From: Green, Victoria - Oxfordshire County Council <Victoria.Green@Oxfordshire.gov.uk>
Sent: Monday, January 22, 2024 1:57 PM
To: Planning <Planning@Cherwell-DC.gov.uk>
Subject: Application Ref: 23/03139/REM

Ref: 23/03139/REM Land Adjoining Withycombe Farmhouse, Straord Road, Drayton

Drawing No: **WE102-LS-004c**

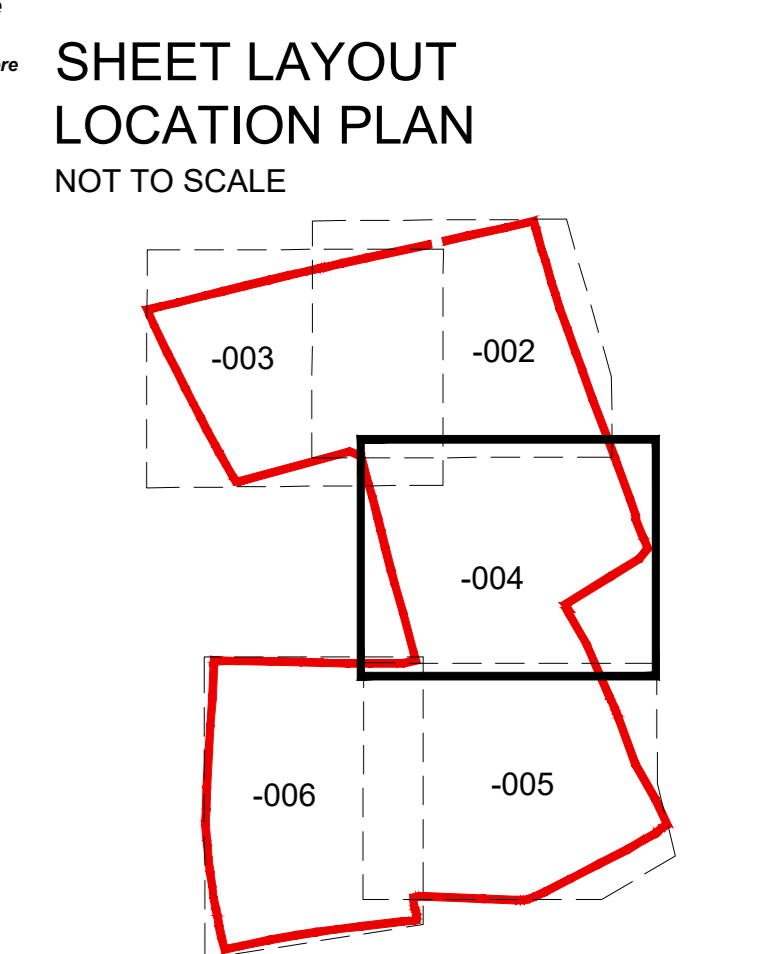
The plans submitted with this Reserved Matters application show native woodland and scrub mix planting, as well as individual trees within the agreed no build area. The plans also show paths additional to those which will be mown running through the no-build area in the northwestern part of the development. This is unacceptable under the agreed WSI, and we will require that these areas of planting are removed from the scheme.

If it is desired that the planting and paths are kept within the landscaping scheme, then a further phase of archaeological mitigation will be required in these areas. The reserved matters cannot be approved at this stage.
